# Appeal Decision

**Appeal Ref: APP/R4408/W/18/3200956**  
**29-31 New Street, Barnsley S70 1RZ**

- The appeal is made under section 78 of the Town and Country Planning Act 1990 against a refusal to grant planning permission.
  - The appeal is made by P & J Textiles against the decision of Barnsley Metropolitan Borough Council.
  - The application Ref 2017/0118, dated 23 January 2017, was refused by notice dated 8 November 2017.
  - The development proposed is described as extension to retail premises with single 2 bedroom residential unit over.
-

**PROPOSED
FIRST FLOOR LAYOUT**

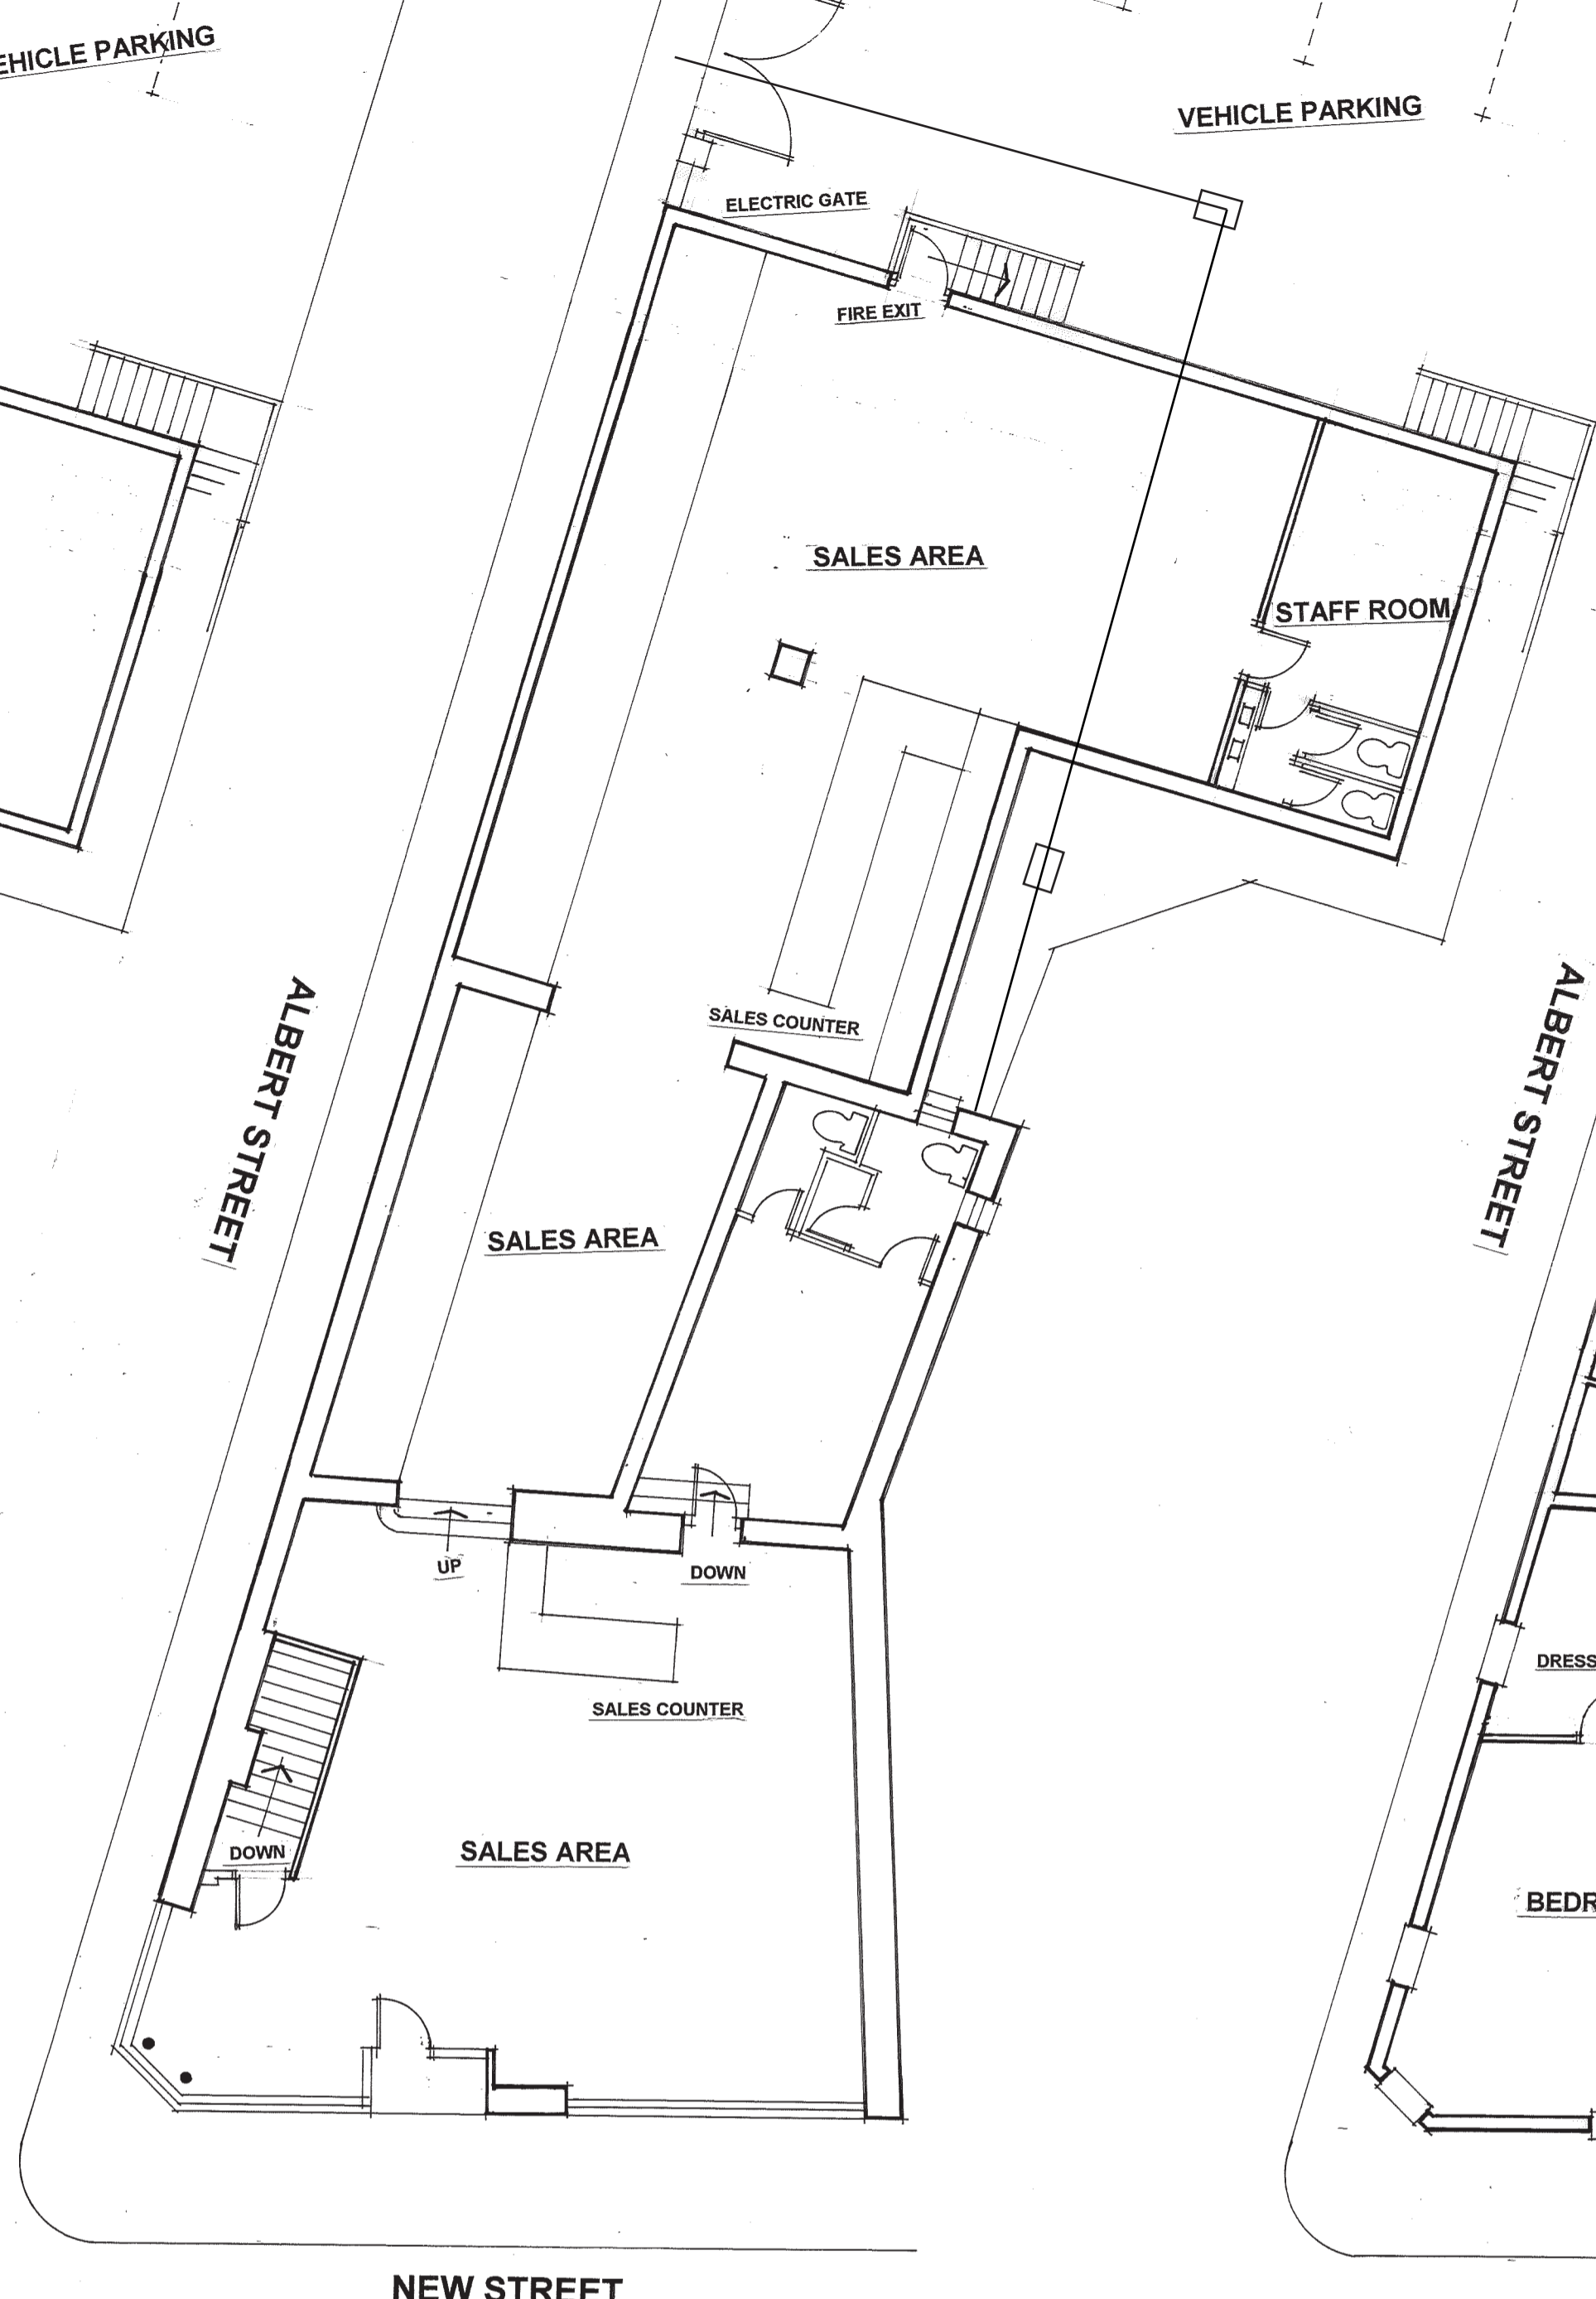
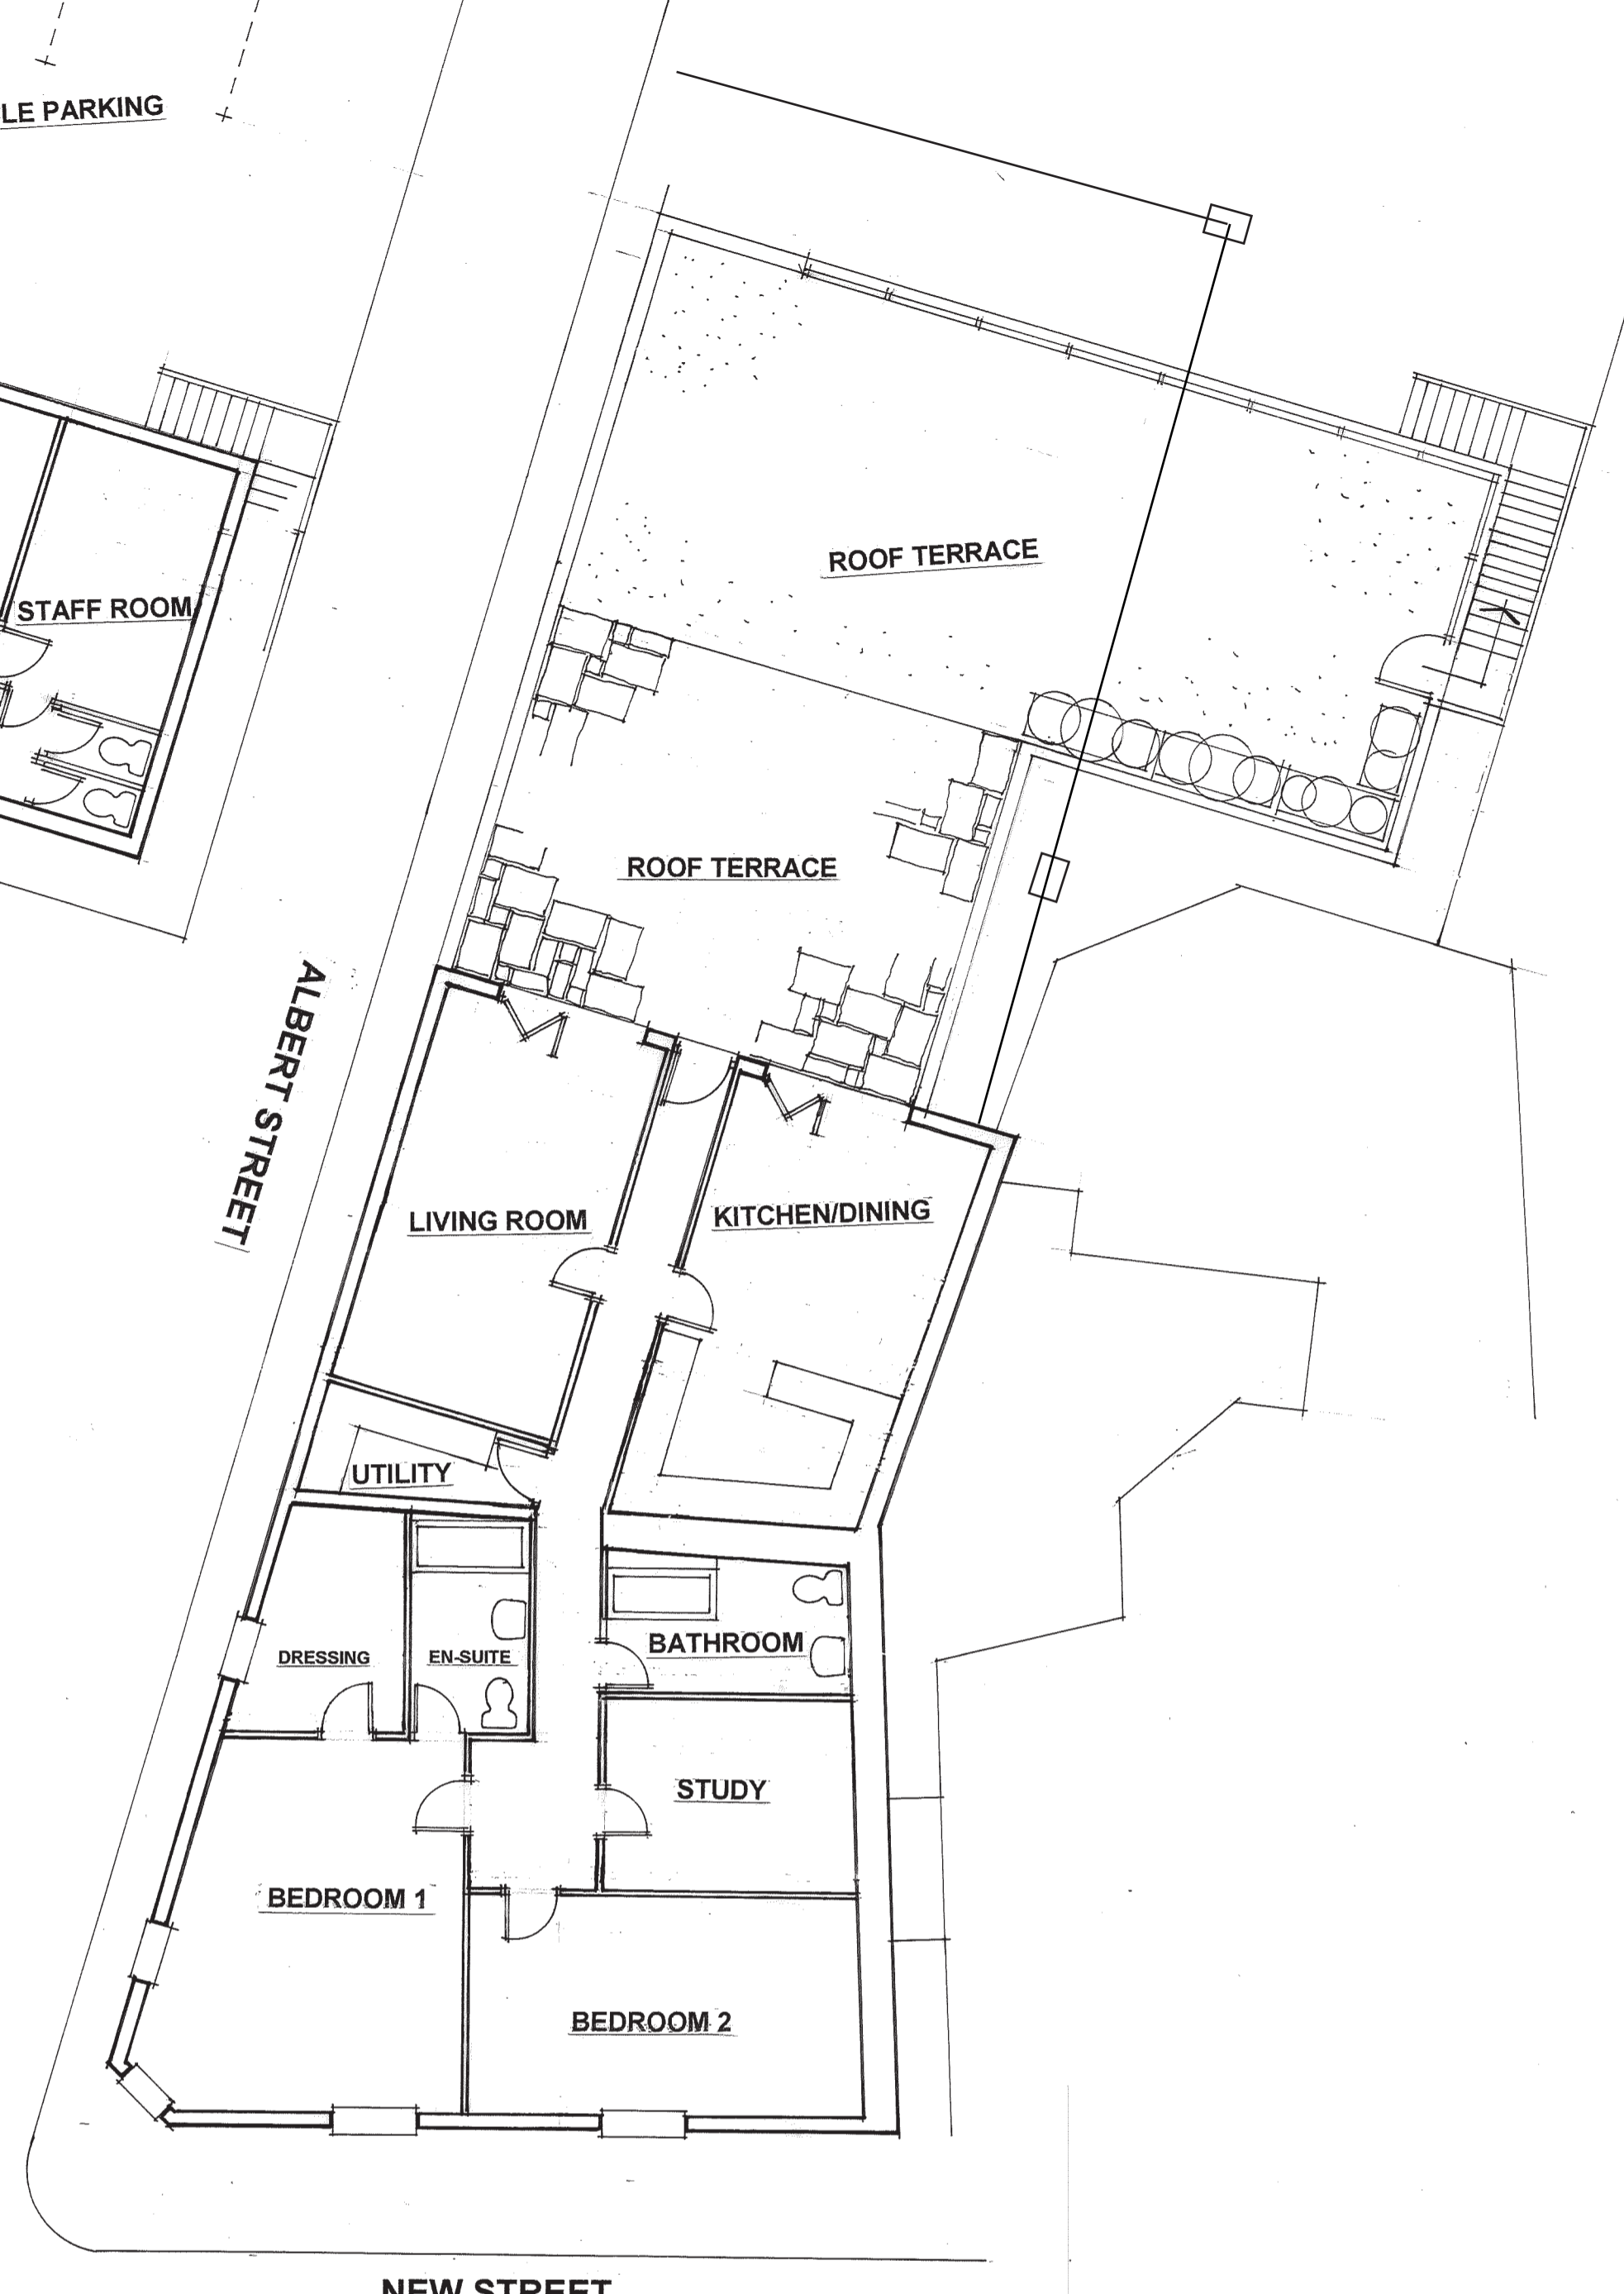
7. The appeal proposal would result in a 2 bedroom residential unit on the first floor level of No 29-31. A substantial proportion of the floor area would be occupied by an open roof terrace. This would be accessed by folding doors from both the living and kitchen/dining rooms within the proposed residential unit. I consider that this arrangement would provide opportunities and encourage future occupiers to use the roof terrace in conjunction with these 2 rooms, particularly in good weather.

8. I note the contents of the noise report submitted with the planning application. I have no reason to question that the proposed combination of glazing, acoustic insulation and mechanical ventilation would mitigate noise levels within the proposed residential unit. However, these measures would only be wholly effective when the folding doors to the roof terrace were closed. Given the high likelihood of the roof terrace being used in conjunction with the living room and kitchen/dining room with the folding doors open, I consider these measures would not always be effective.

9. The measures would not be effective at all for future occupiers using the roof terrace. Given its significant nature I consider that future occupiers would be highly likely to make extensive use of the roof terrace. Both the roof terrace and internal areas of the proposed residential unit would also be subject to cooking odours from the ventilation/extraction systems of nearby premises. Taking account of the amount of hot food related premises in the vicinity and their hours of operation, there would be likely to be significant odour issues, particularly at night time.

11. In light of the above, I conclude that future occupiers of the proposed residential unit would be subject to unacceptable levels of noise and odour. Consequently, they would not be afforded an adequate standard of living conditions. The appeal proposal would therefore conflict with Policy CSP40 of the Core Strategy<sup>1</sup>. This seeks to resist residential development in locations where there are unacceptable levels of pollution and no reasonable prospect of mitigation.
